KIRKLEES METROPOLITAN COUNCIL INVESTMENT & REGENERATION SERVICE

Reference No:	2025/62/91008/E
Site Address:	23, Quarryside Road, Mirfield, WF14 9QQ
Description:	Erection of conservatory to rear
Recommending Officer:	Faiza Bano

HOUSEHOLDER DELEGATED REPORT

Title -
PROPOSED ELEVATIONS (2 of 4)

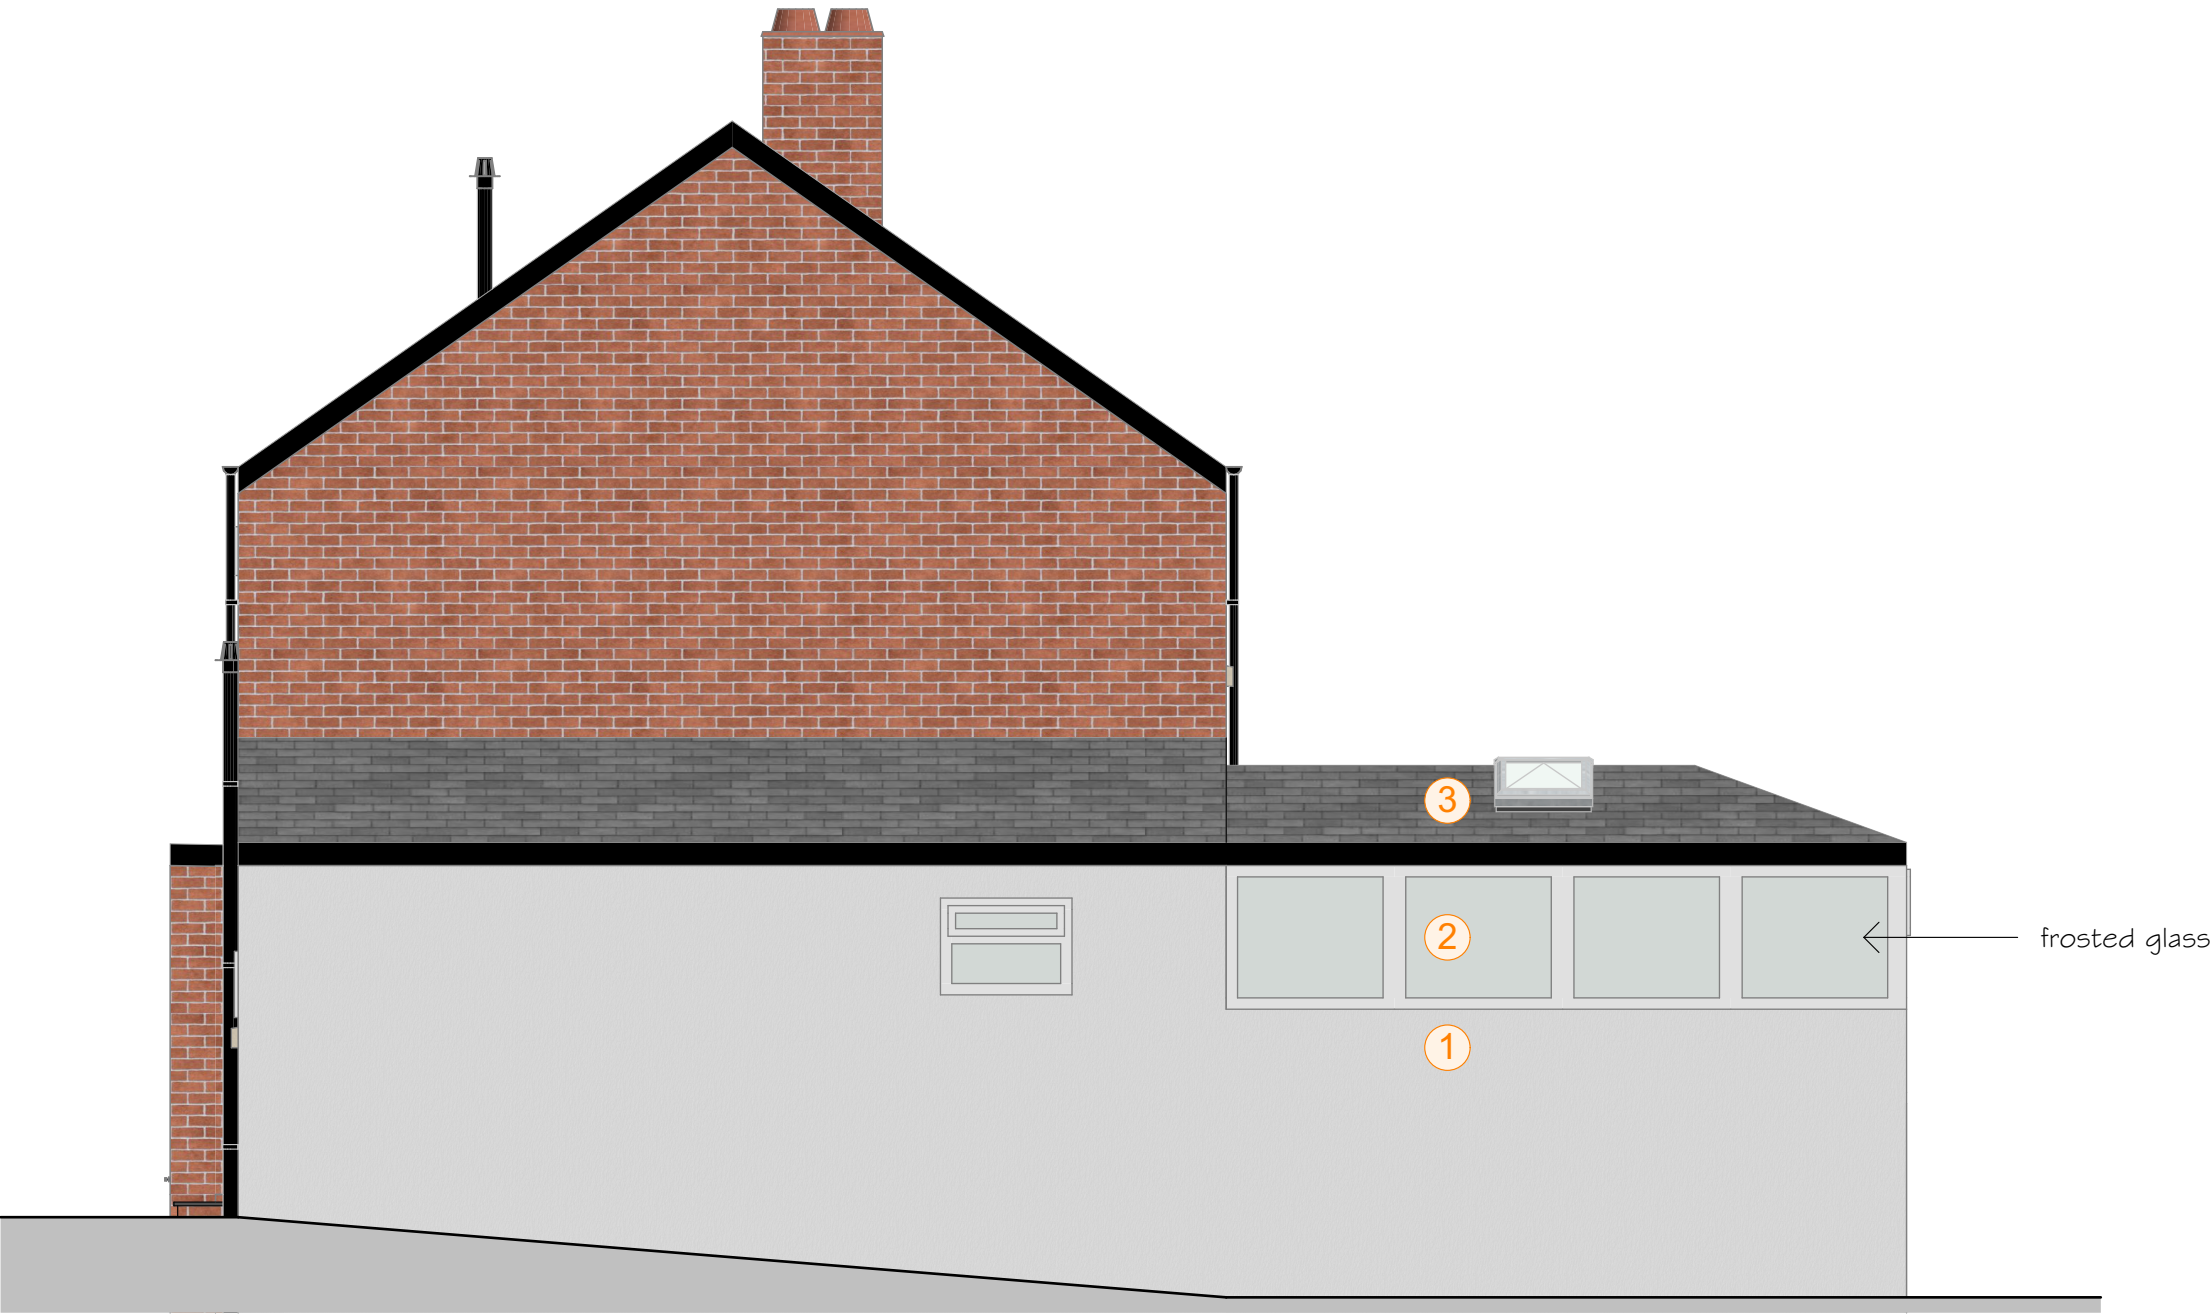
where they exceed 3m in length the eaves height should generally not exceed 2.5 meters; and	Yes – eaves height is 2.4m from ground floor level	
retain a gap of at least 1 metre from a property boundary, such as a wall, fence or hedge.		No – the extension does not retain a gap, however, the dwellings are detached and the neighbouring property, number 25, sits further back than the application site – the rear building line is 2m away from the rear building line of number 23. This also ensures it doesn't breach the 45 degree rule.

1. The individual objects to the proposed conservatory on the grounds that it does not maintain a minimum gap of 1 metre from the boundary. Additionally, its position and height would negatively impact the natural light currently enjoyed in their property. The window facing the garden would directly overlook their garden, compromising privacy, and the conservatory would significantly reduce the outlook from their property.

2. The individual wishes to formally object to the planning application, noting that the site indicates objections are closed, but the paper notice was only displayed on the street on June 4th, with a 21-day objection period ending on June 25th, 2025. They highlight inaccuracies in the architect's drawings, which show boundary lines veering to the right and not running parallel with the original structure. The land registry title plan indicates the side boundary narrows towards the rear, making the drawing inaccurate and encroaching on their land. They question the validity of the boundary claimed by the property owner, noting that hedges were removed and a fence erected at the furthest edge of the hedges, as visible on Google Maps.

Officer Response: *The proposed conservatory does not retain a gap from the boundary. However, it is important to note that the neighbouring property does not have any openings along the side elevation that face the application site. This ensures that there will be no direct impact on the natural light or privacy of the neighbouring property.*

Regarding the impact on natural light, the application site's rear building line is positioned two metres beyond the rear building line of the neighbouring property. Consequently, the conservatory will project only 2.5m metres beyond the rear elevation of the objector's property. This limited projection is designed to minimise any significant impact on the natural light currently enjoyed by the neighbouring property.

In terms of privacy concerns, the windows facing the garden are designed with obscure glazing. This feature effectively mitigates privacy concerns by preventing direct views into the neighbouring garden, thereby maintaining the privacy of both properties.

Finally, given the conservatory's 2.5m projection beyond the rear building line of the objector's property, the impact on the outlook is considered minimal. The design and positioning of the conservatory have been carefully planned to ensure that the outlook from the neighbouring property is not significantly compromised.

The submitted site plan also indicates that the side boundary narrows towards the rear.
